**KIRKLEES METROPOLITAN COUNCIL  
INVESTMENT & REGENERATION SERVICE**

Reference No:	<b>2023/62/93749/E</b>
Site Address:	77 , Latham Lane, Gomersal, Cleckheaton, BD19 4AP
Description:	Erection of detached dwelling with integral garage (amended house type)
Recommending Officer:	Nicole Helliwell

## **Officer Report**

**Proposal:** Erection of detached dwelling with integral garage (amended house type)

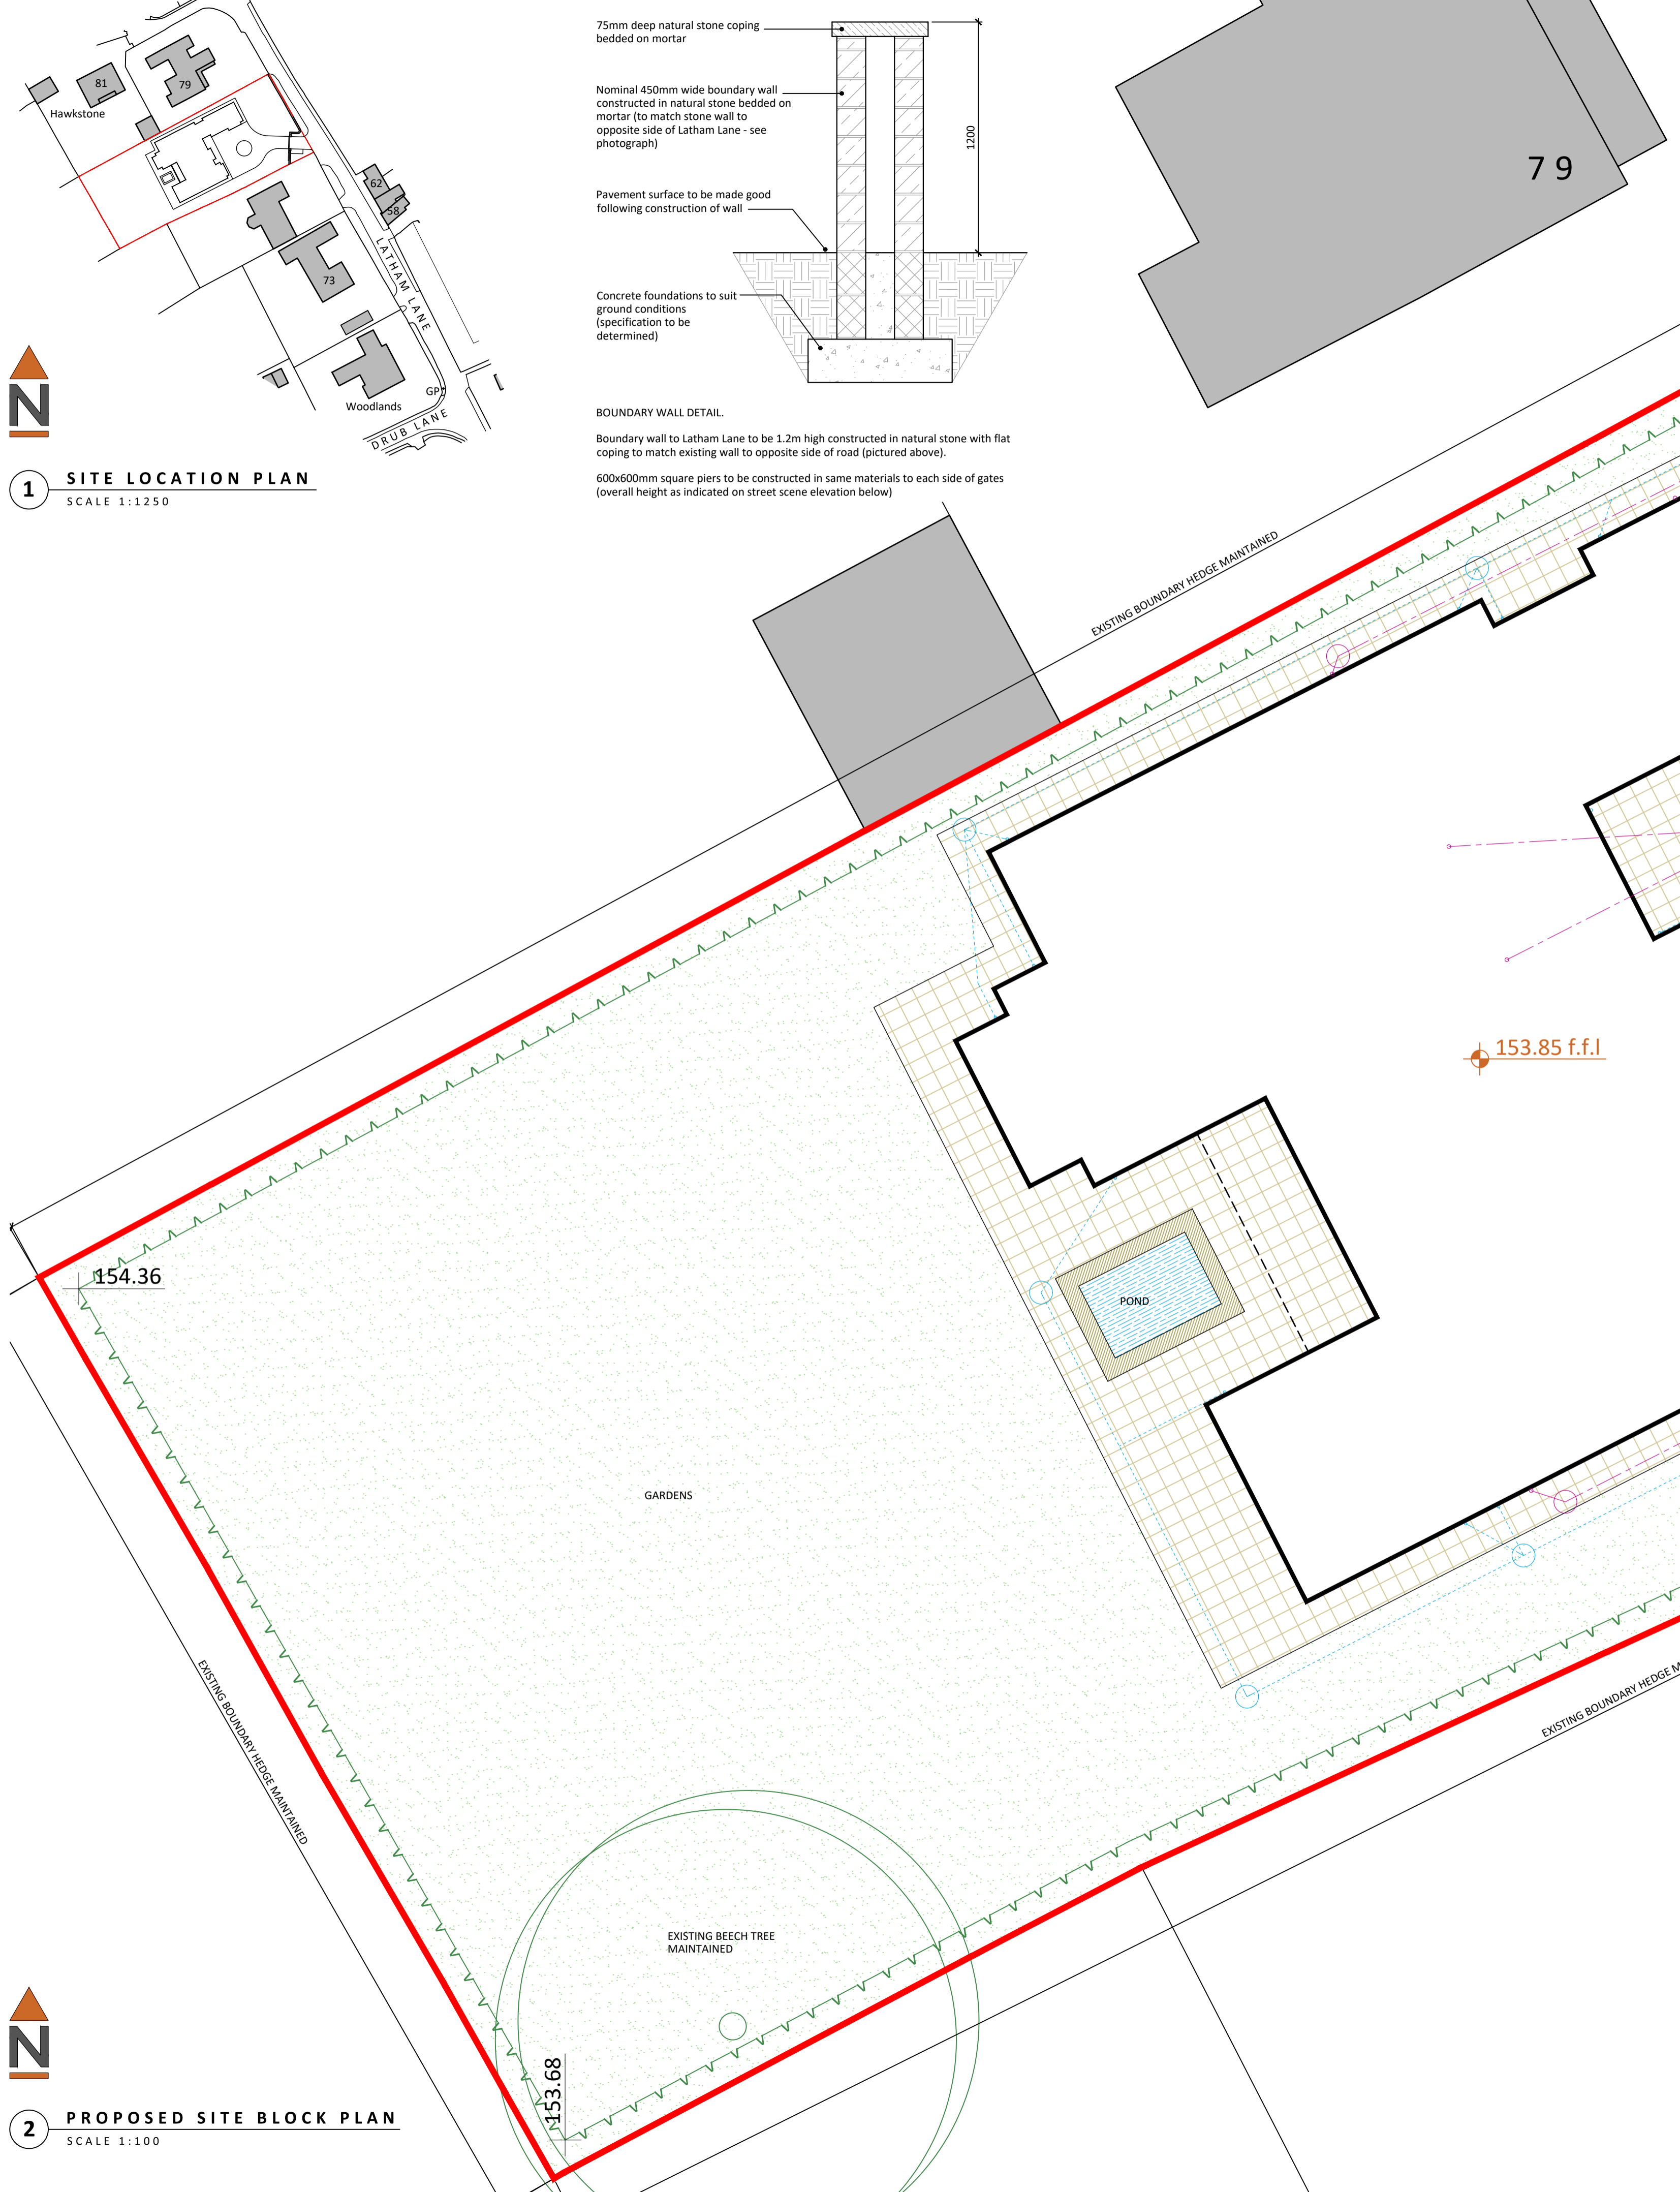
Details of the proposed boundary treatments have been provided with the application. The submitted plans confirm that the existing hedge would be retained to the south, west and northern boundaries of the application site. Furthermore, a 1.2m high boundary wall would be erected along the eastern boundary of the site. The submitted plans confirm that the wall would be constructed in natural stone with flat coping. The proposed

boundary treatment would be in keeping with the existing wall at the opposite site of the road and would not cause any significant harm to visual amenity.

4. The 1.2m high boundary wall hereby approved along the eastern boundary of the site shall be constructed in natural stone with flat coping. The materials of construction shall thereafter be retained for the lifetime of the development.

1 PROPOSED NORTH-WEST ELEVATION
SCALE 1:50

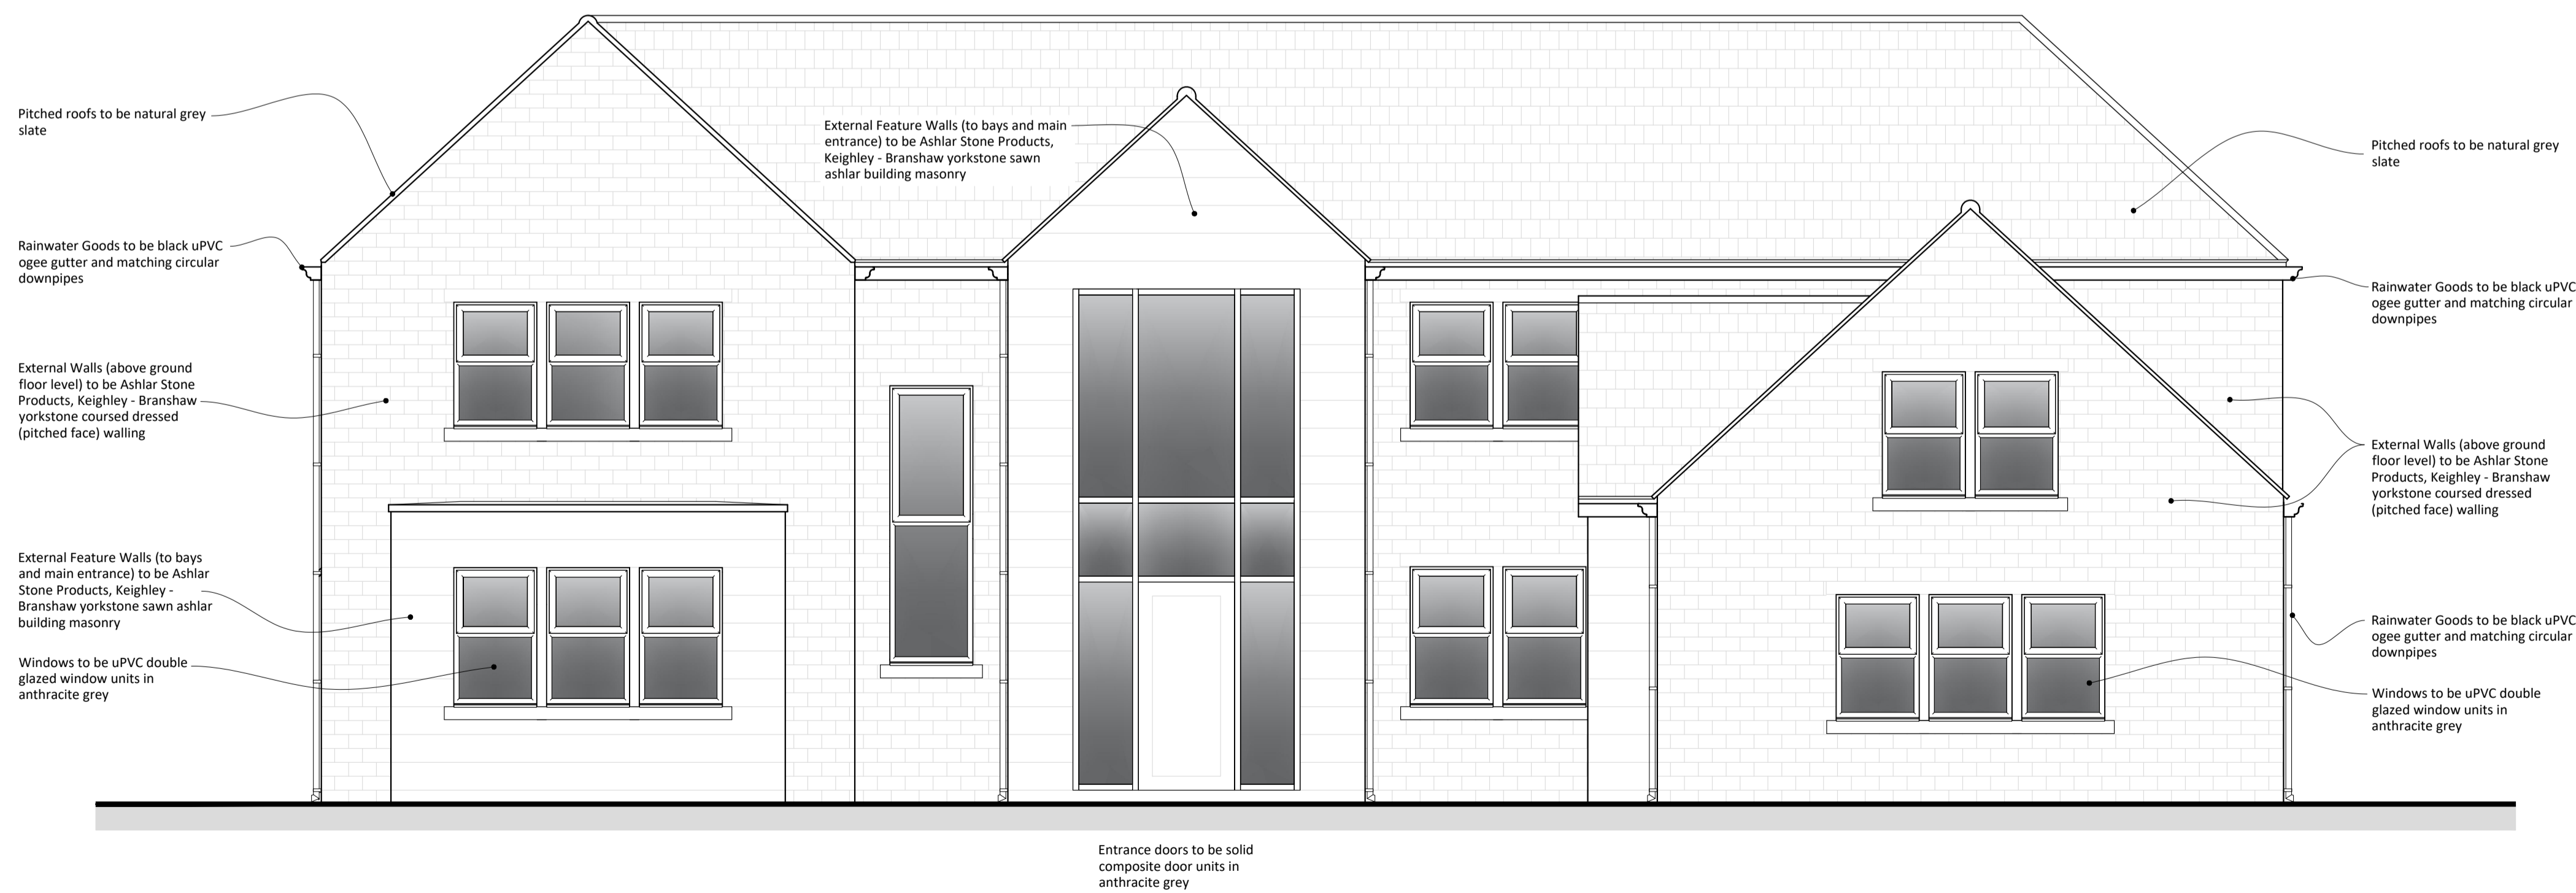
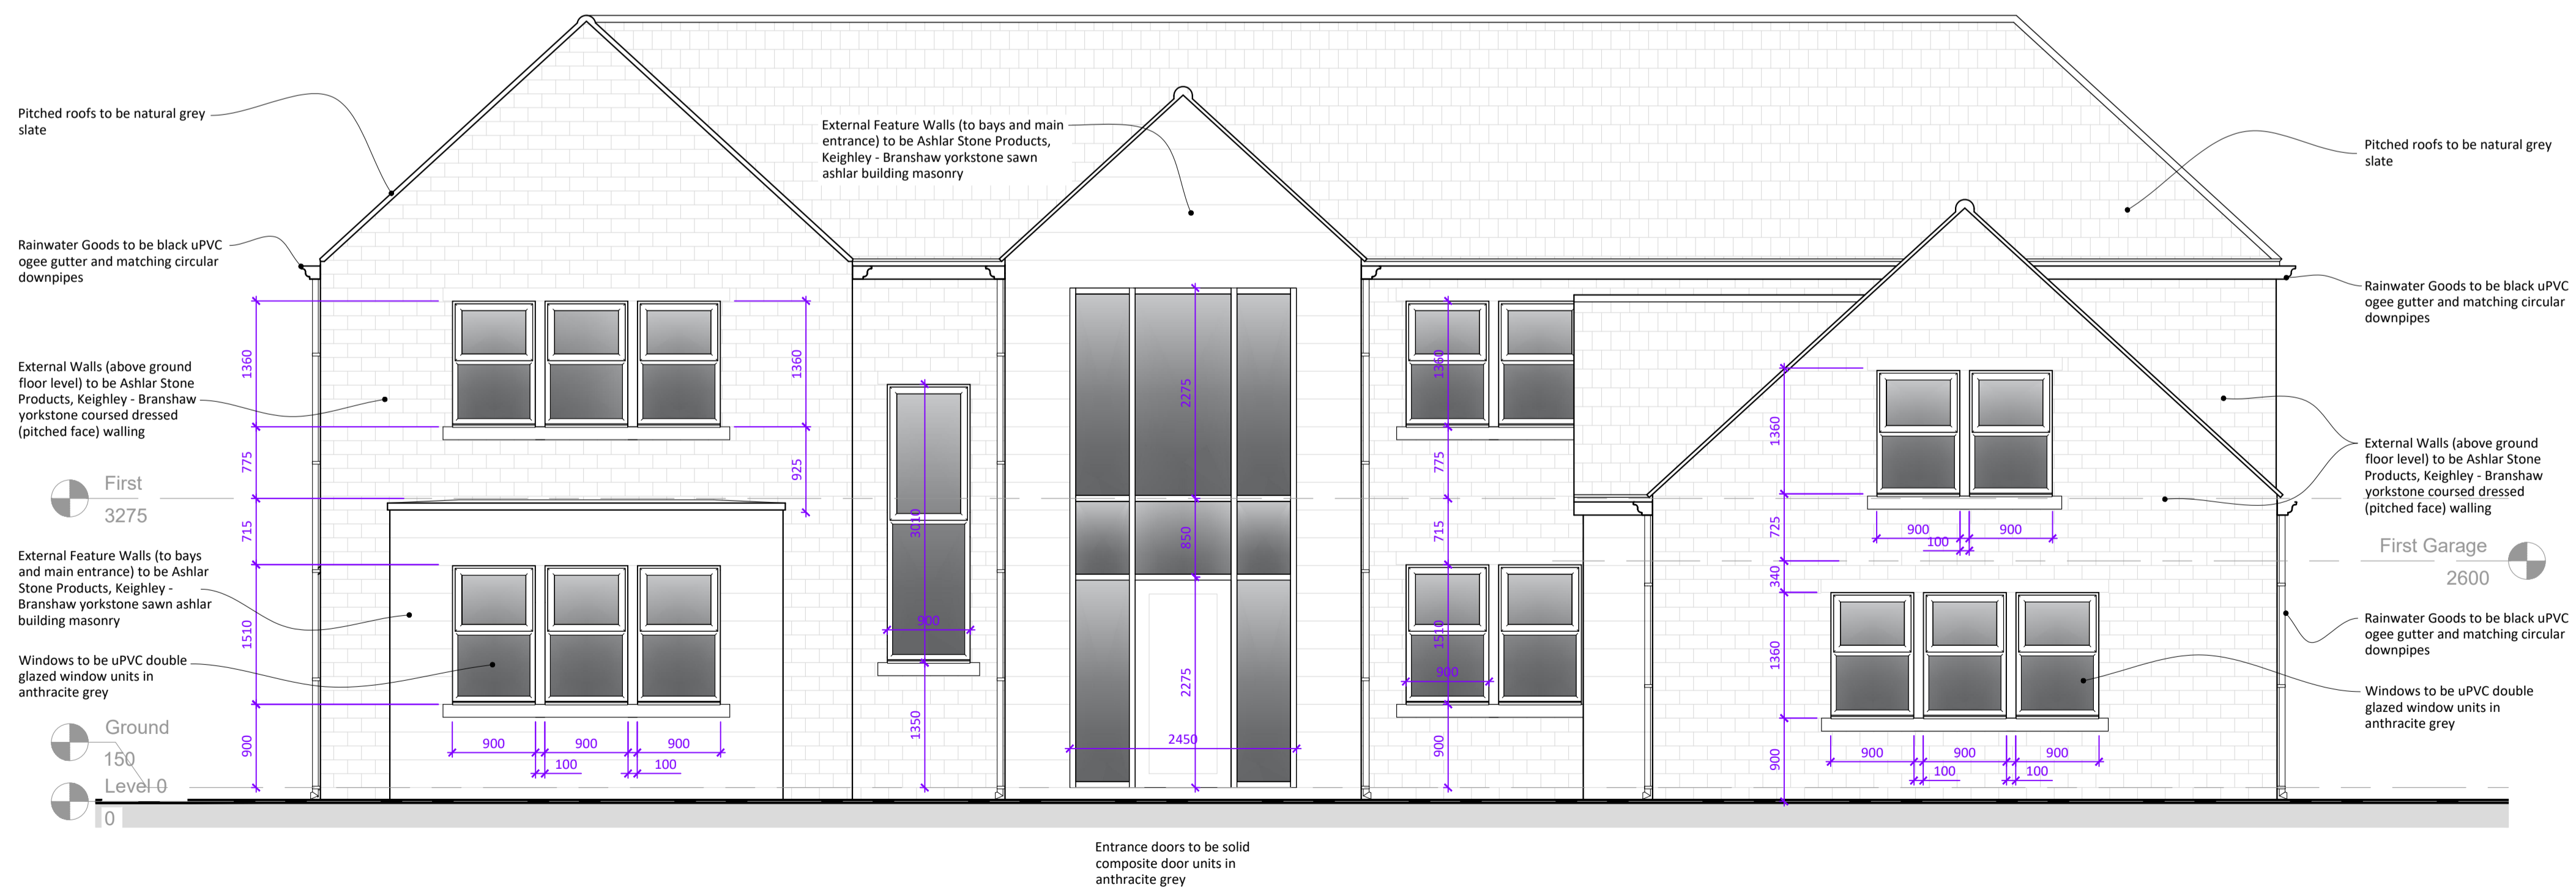
The plans initially showed two heat source pumps on the proposed north-west elevation of the detached dwelling. KC Environmental Health did have concerns that the air source heat pumps may cause harmful noise pollution within neighbouring noise sensitive locations and therefore, recommended a condition requiring a noise report to be submitted. However, the two heat source pumps have since been removed from the application and therefore, it is no longer considered necessary to condition a noise report.

Revised plans were received during the course of the application. The applicant's agent removed the two heat source pumps from the plans to prevent the requirement for a noise report.
